MEMORANDUM

SUBJECT: AASI-21-003 – Grandview Reserve  
Third Submittal (second Engineering review)

**Engineering Division**

Haul Route Exhibit

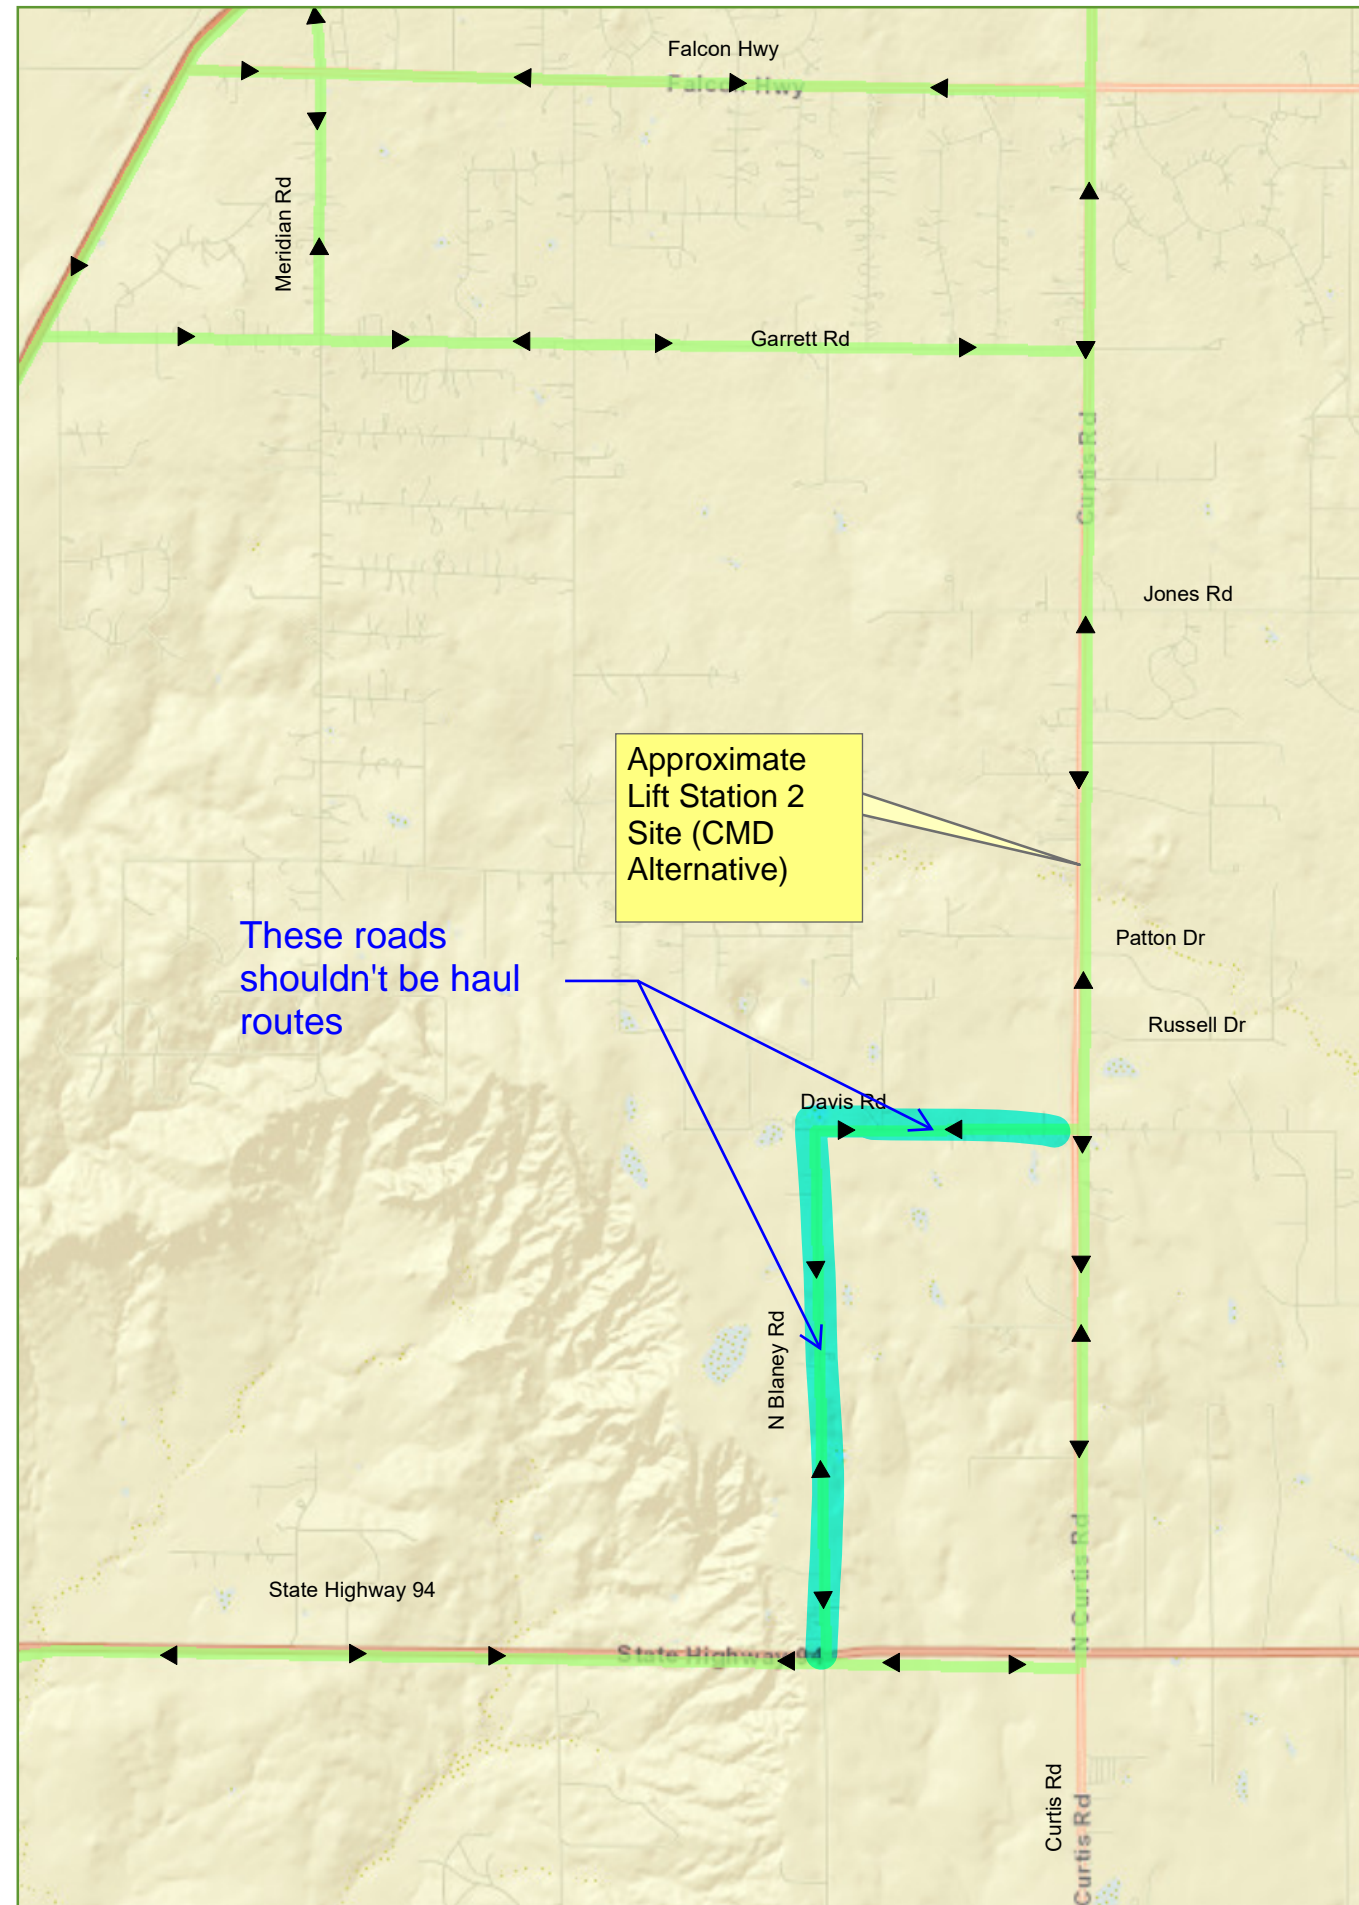
**Provide a construction traffic analysis addressing construction traffic and the proposed haul routes. Depending on the roads used and the type and number of loads, the ECM Administrator may require a Haul Route Agreement. Address whether temporary access will be requested from Highway 24. Address vehicle types and weights proposed to be utilized during construction and the anticipated construction timeframe in months for the utility facilities.**

**The haul route map should narrow down route options; see redlines. Once there is a better understanding of which roads will be used, how much construction traffic and what type of loads, Staff will address potential degradation fees.**

*Exhibit redlines have been addressed.*
